KIRKLEES METROPOLITAN COUNCIL INVESTMENT & REGENERATION SERVICE

DELEGATED DECISION TO DETERMINE PLANNING APPLICATIONS

Reference No:	2026/62/91664/W
Site Address:	adj, 5, Fernside Avenue, Almondbury, Huddersfield, HD5 8NR
Description:	Demolition of existing building and erection of dwelling
Recommending Officer:	Joanna Rednall

Officer Report 2026/91664

PROPOSED FRONT (SE) ELEVATION
1:100

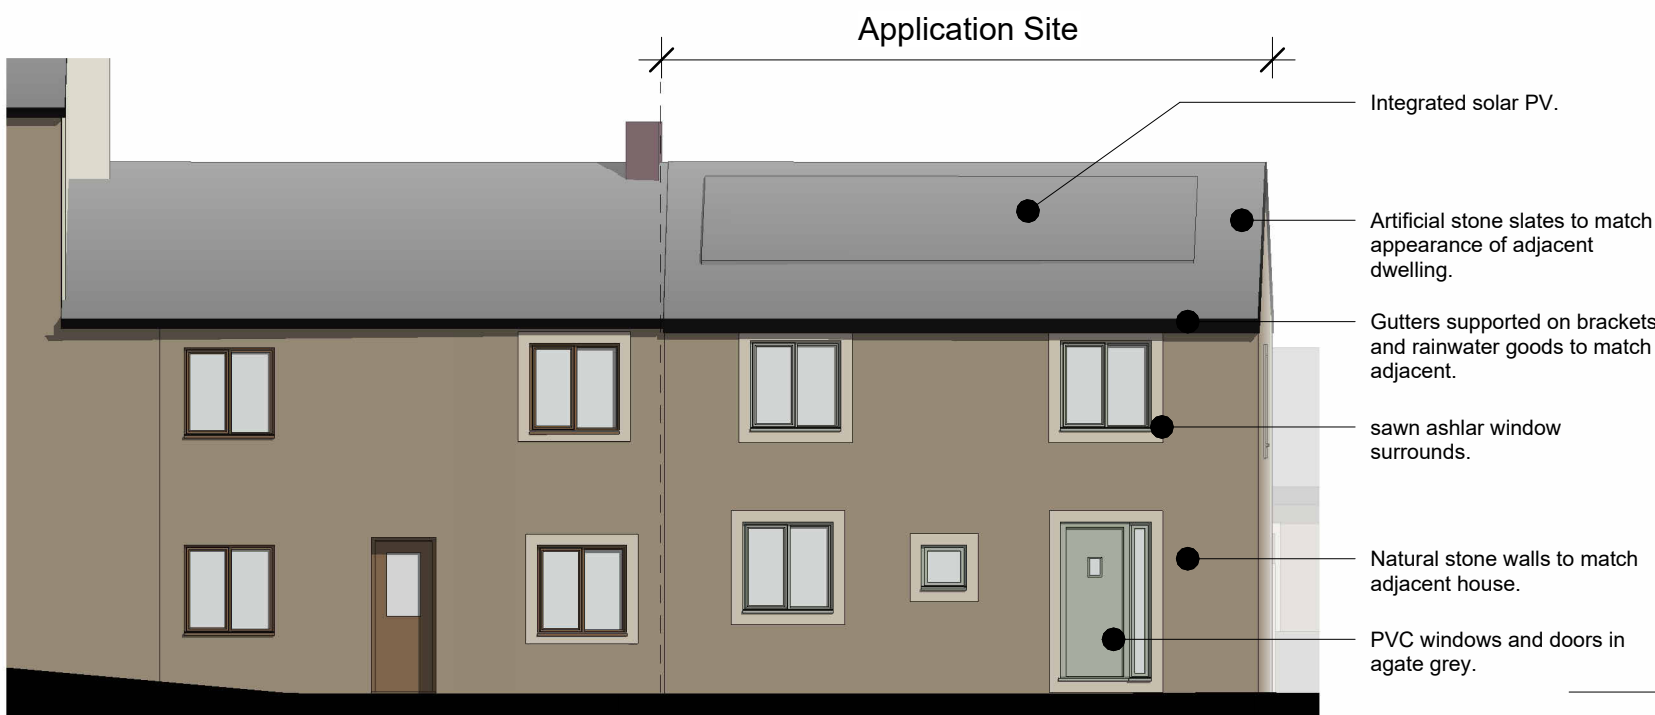
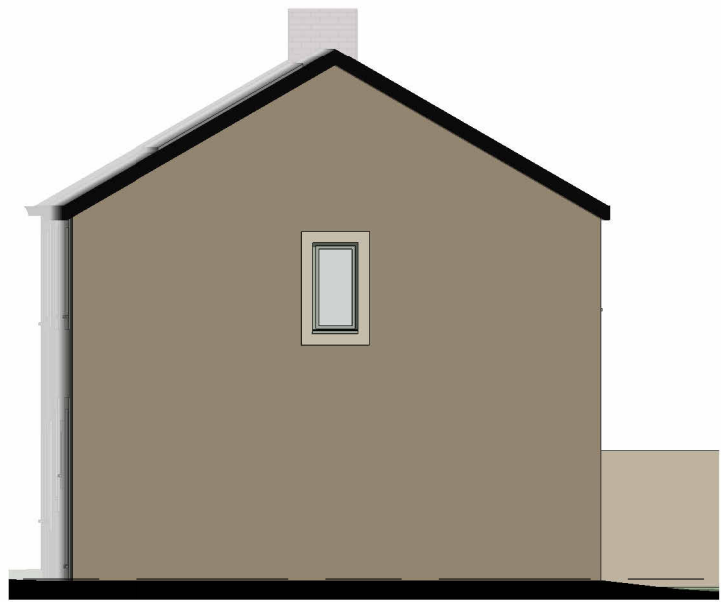
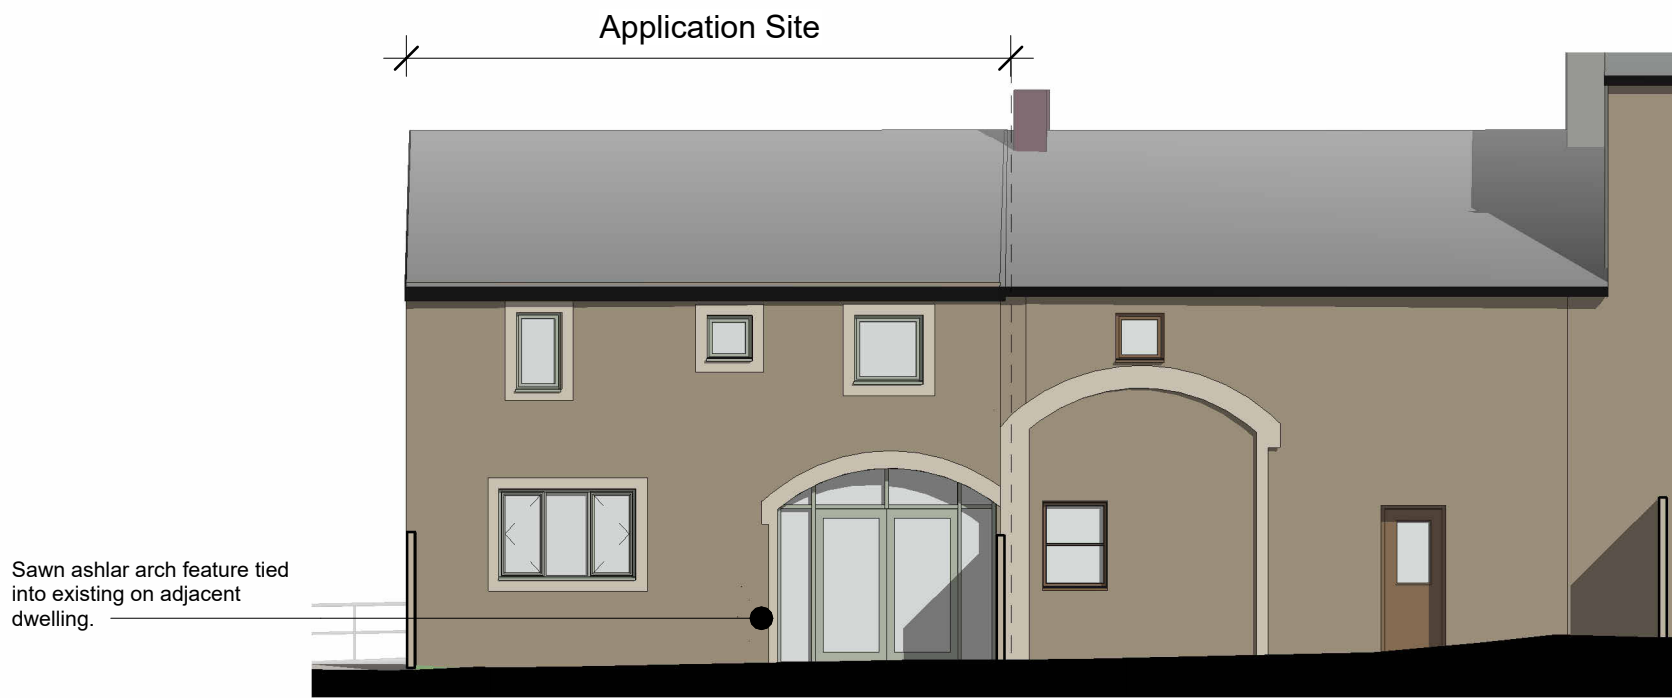
Given the sensitivity of the site, it is recommended however that gutters are supported by corbels or brackets, not fixed to a fascia board, and are of traditional profile, and that gable ends are terminated with a mortar joint not bargeboards, in the interests of ensuring that they harmonise with the traditional appearance of no. 5 as well as the listed 1-3 and do not give rise to a jarringly modern feature.

In the interests of visual amenity and to ensure that the solar panels are appropriately integrated into the proposed roofscape, the Conservation Officer has recommended a condition requiring the panels to comprise black glass with black frames, with no silver linings, and to have a non-reflective finish. This is considered reasonable and necessary to minimise their visual prominence and ensure that they do not detract from the character and appearance of the development or the surrounding area.

4. Gutters shall be supported by corbels and shall not be fixed to a fascia board.

5. Gable ends shall be terminated with a mortar joint and without bargeboards.

11. Notwithstanding the submitted details, the solar panels hereby approved to the front / south east facing elevation shall be all black, with no silver linings and shall have a non-reflective coating. The panels shall retained as such thereafter.

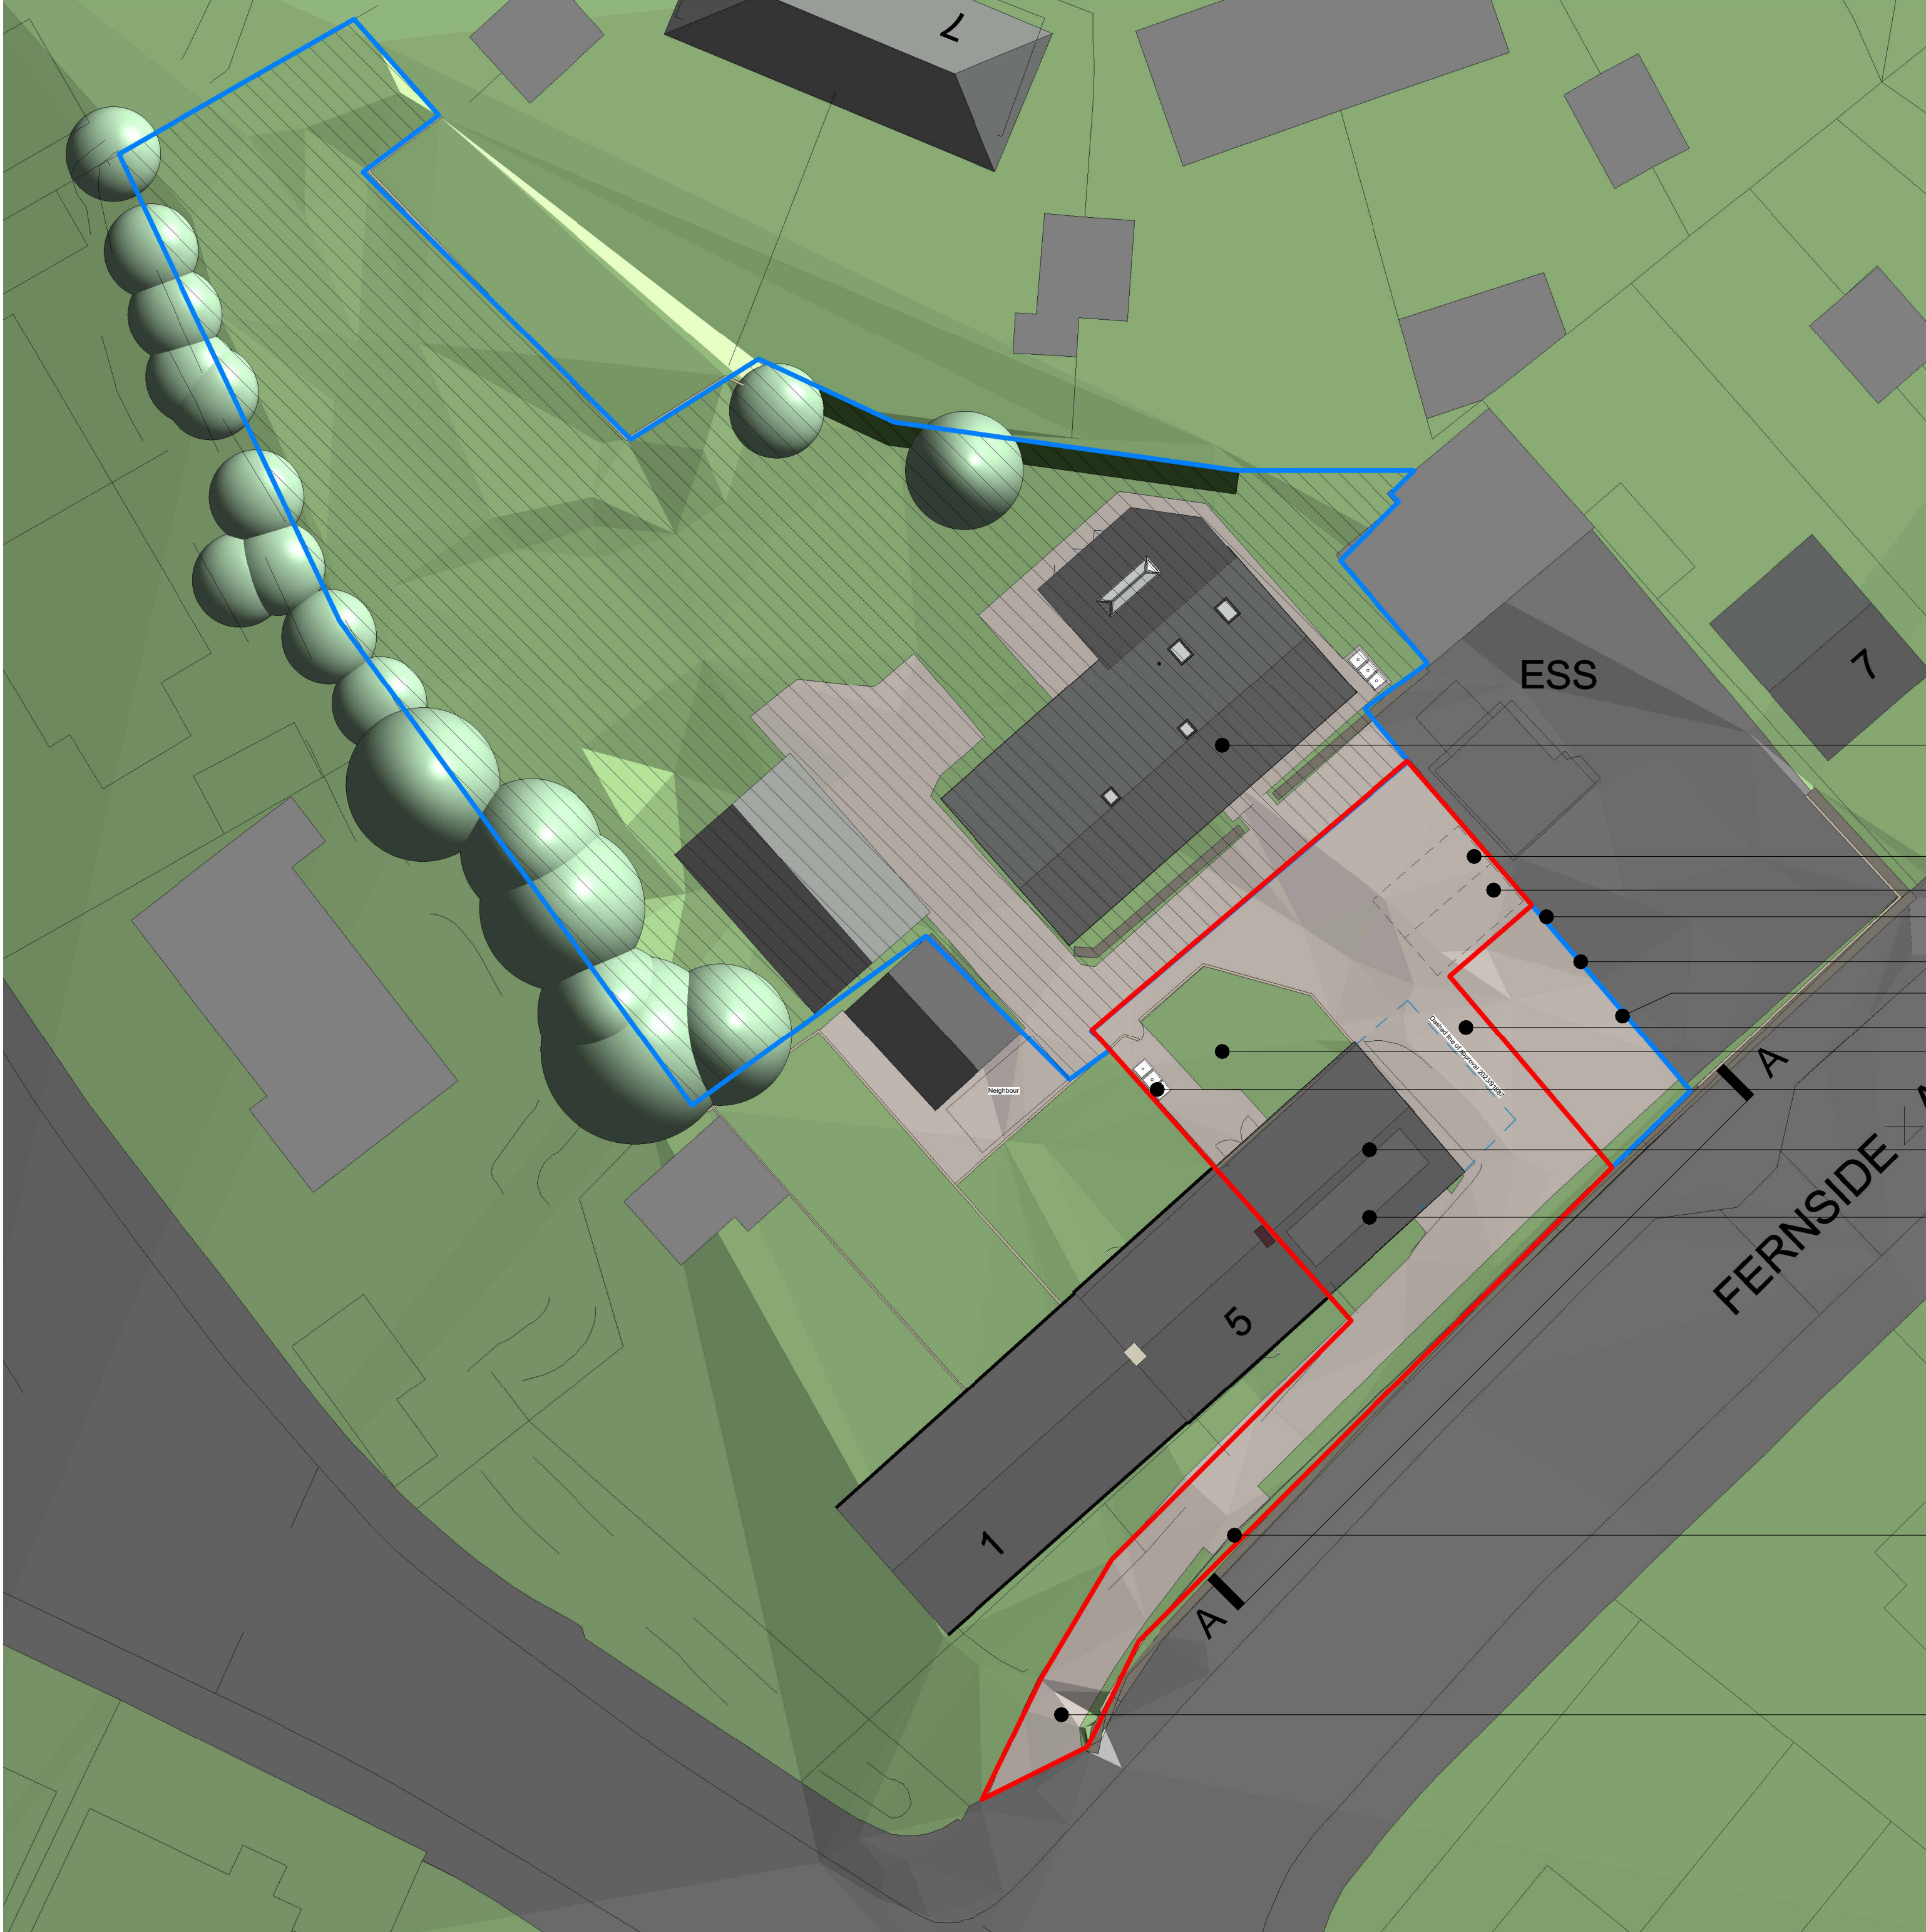
The plans demonstrate a designated bin storage area to the rear of the dwelling, along with two off street parking spaces to the side along with associated turning areas. The Council's Highways Development Management team have been consulted on the proposal and have provided the following comments:

The approved vehicle parking areas will need to be surfaced and drained in accordance with the Communities and Local Government; and Environment Agencies ‘Guidance on the permeable surfacing of front gardens (parking areas)’ published 13th May 2009 (ISBN 9781409804864) as amended or superseded.”

6. Prior to the development being brought into use, the approved vehicle parking areas shall be surfaced and drained in accordance with the Communities and Local Government; and Environment Agencies 'Guidance on the permeable surfacing of front gardens (parking areas)' published 13th May 2009 (ISBN 9781409804864) as amended or superseded; and thereafter retained throughout the lifetime of the development. The areas used for the parking and turning of vehicles shall thereafter be retained and kept free of all obstructions to their use for the parking and turning of vehicles.

7. The areas indicated to be used on the proposed site plan for the storage and collection of wastes shall be laid out with a hard surface and made available for use before the dwelling to which they relate is first occupied, and shall thereafter be retained as such, free from obstructions to the storage and collection of wastes.
